March 20, 2024
Revised May 22, 2024
Revised June 14, 2024

Subject: Geologic Hazards Evaluation and
Preliminary Geotechnical Investigation
Response to El Paso County Review Comments
Grandview Reserve, Phase 1, Filing 1
Eastonville Road and U.S. Highway 24
Falcon, Colorado
CTL|T Project No. CS19345-115

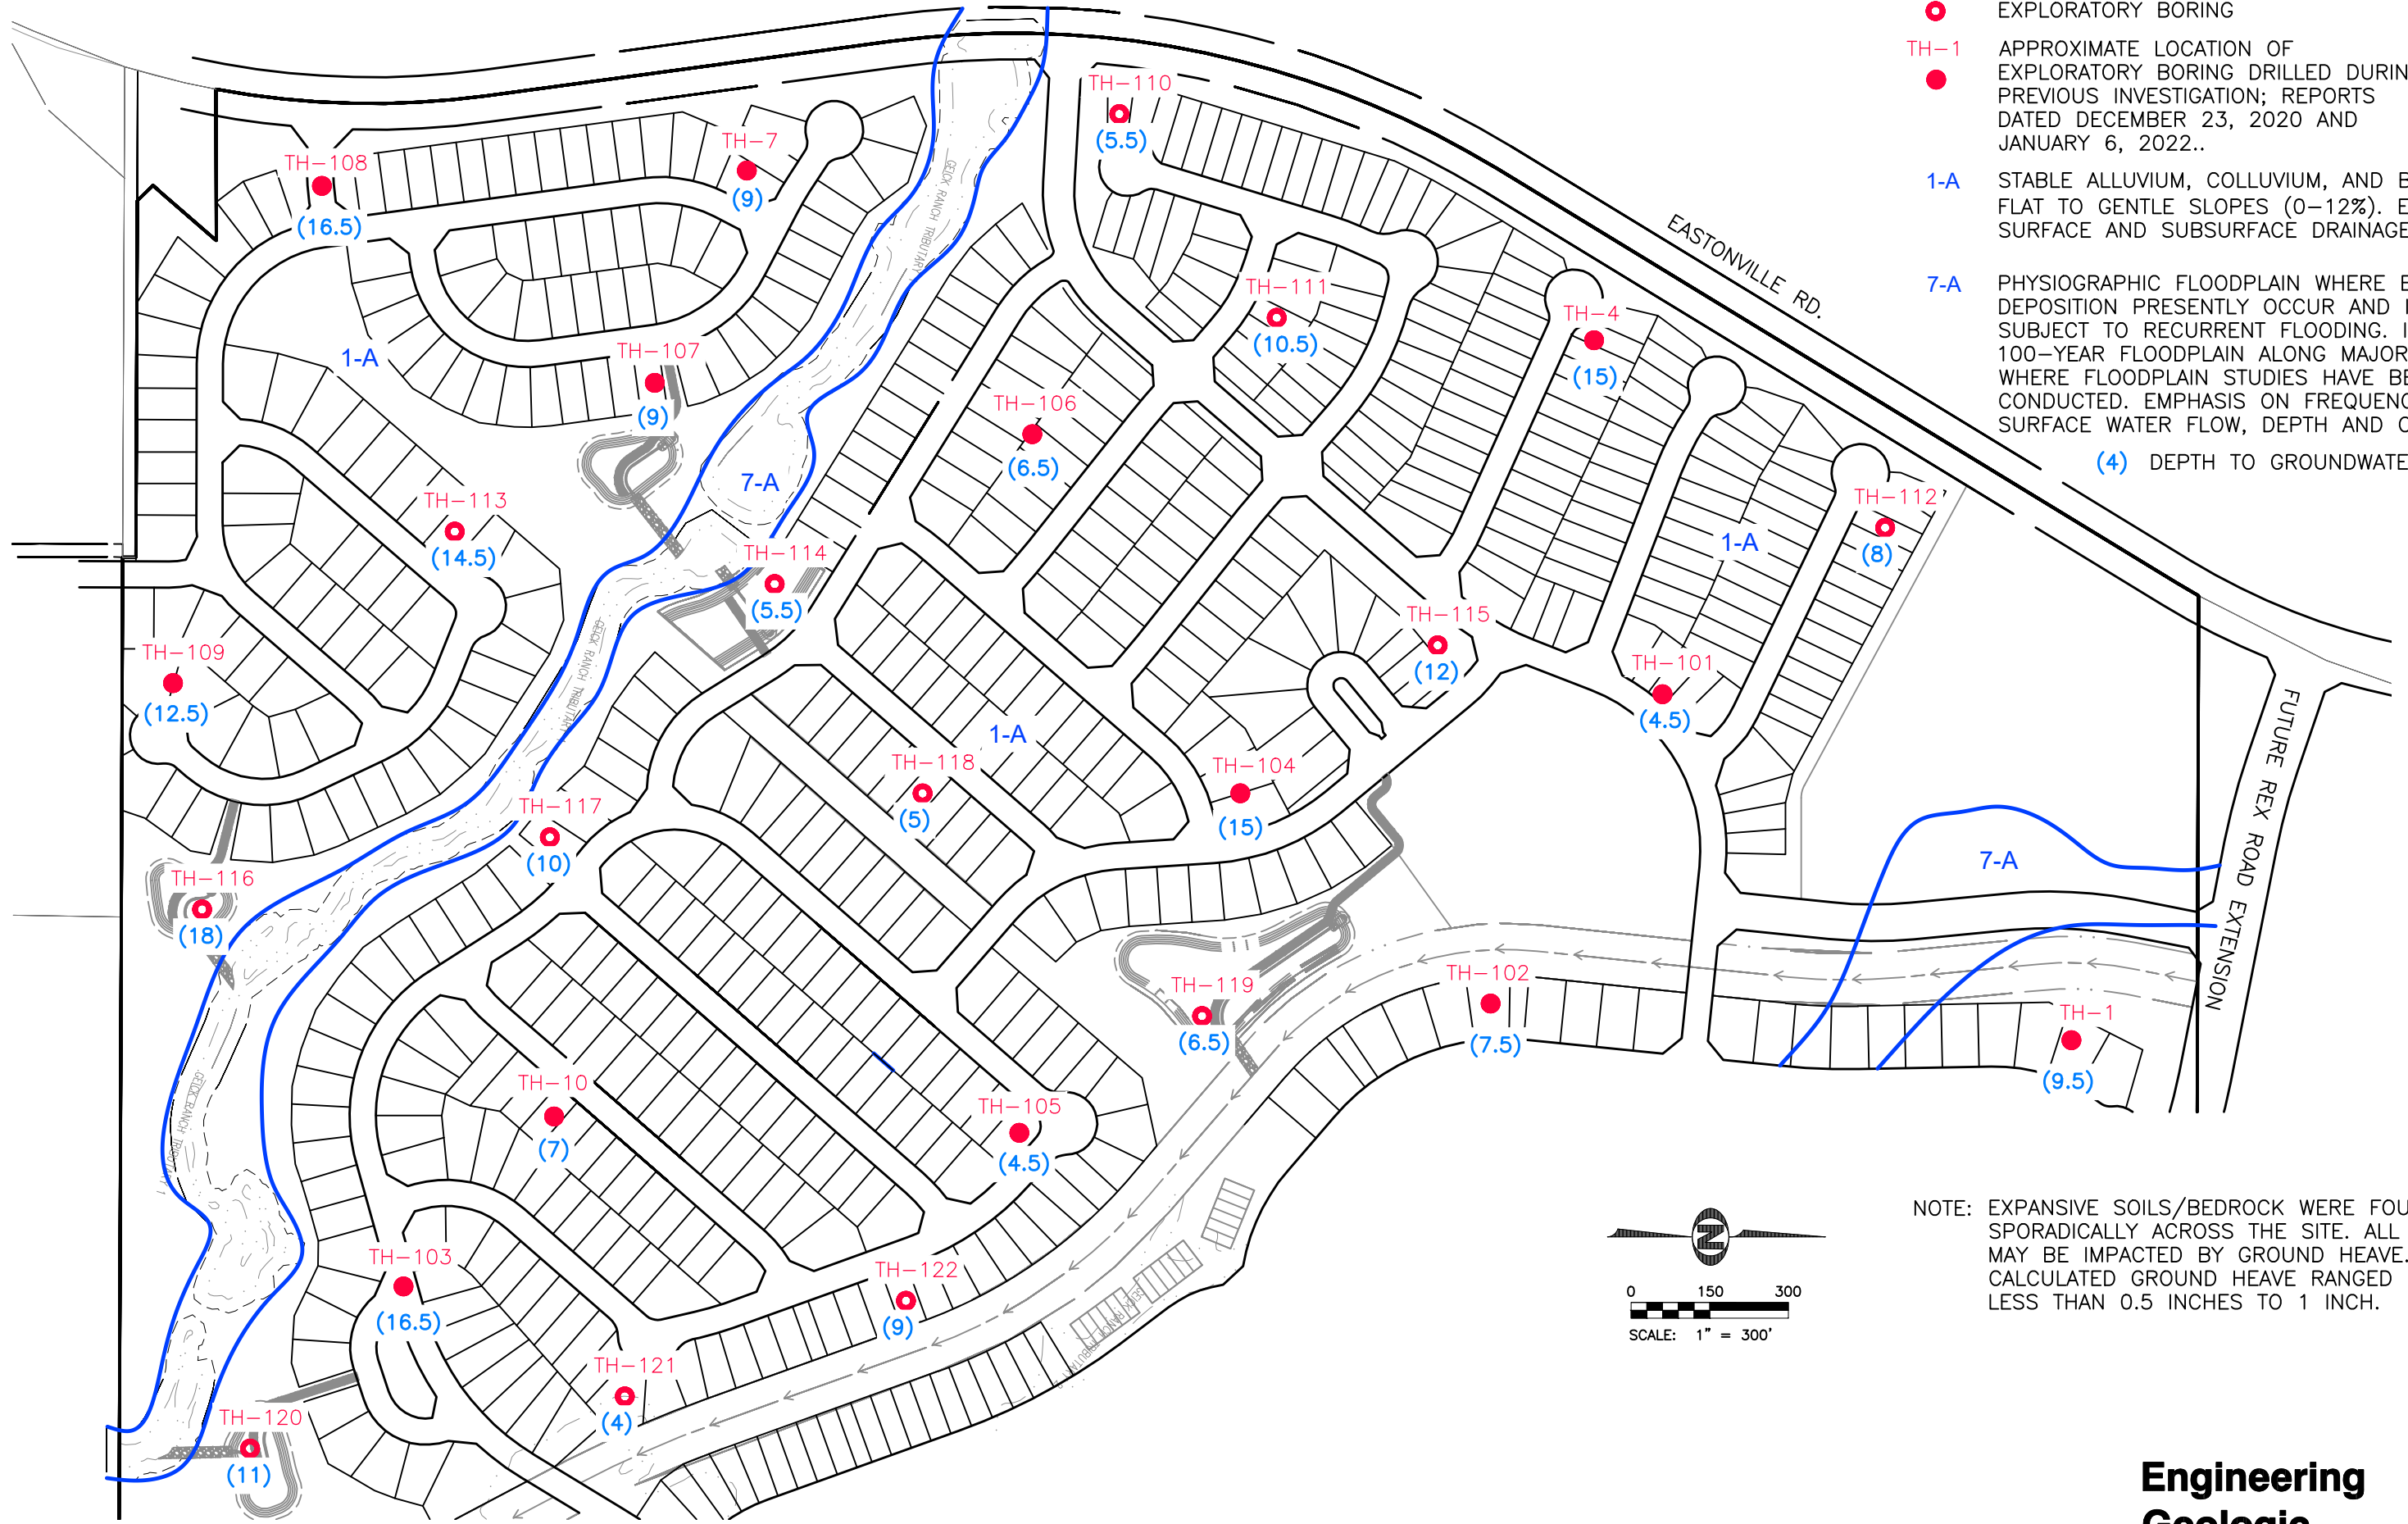
“A figure is missing depicting the various constraint and hazard mapping over the lot layout which was deferred from the prelimplan – see sample.” El Paso County requests that the subsurface conditions, site geology, and each of the geologic hazards including shallow groundwater, unusually hard rock which may cause problems with excavation, expansive soils, flooding, seismicity, erosion, radon/radioactivity, and recoverable minerals be mapped, along with estimated heave potential.

The referenced report contains a figure titled Engineering Geologic Conditions (Fig. 2). The figure indicates areas of the mapped physiographic floodplain and areas of stable alluvium. We also revised Figure 2 (attached) to clarify our interpretation of the engineering geology and to depict where flowing water may be present (in the channel) and where seasonally shallow groundwater is likely (remainder of site). A note is indicated on Figure 2 that states “Expansive soils/bedrock were found sporadically across the site. All lots may be impacted by ground heave. Total calculated ground heave ranged from less than 0.5 inches to 1 inch.” This note was included because the Dawson Formation, which underlies the site at relatively shallow depths, contains interbed-

ded and discontinuous layers of expansive claystone bedrock. This material cannot be mapped with any reasonable degree of accuracy, and it should be expected that expansive claystone may be encountered anywhere on the site. As stated in our report, lot specific soils and foundation investigations should be performed, following completion of overlot grading, to determine where expansive claystone is present and provide recommendations for mitigation.
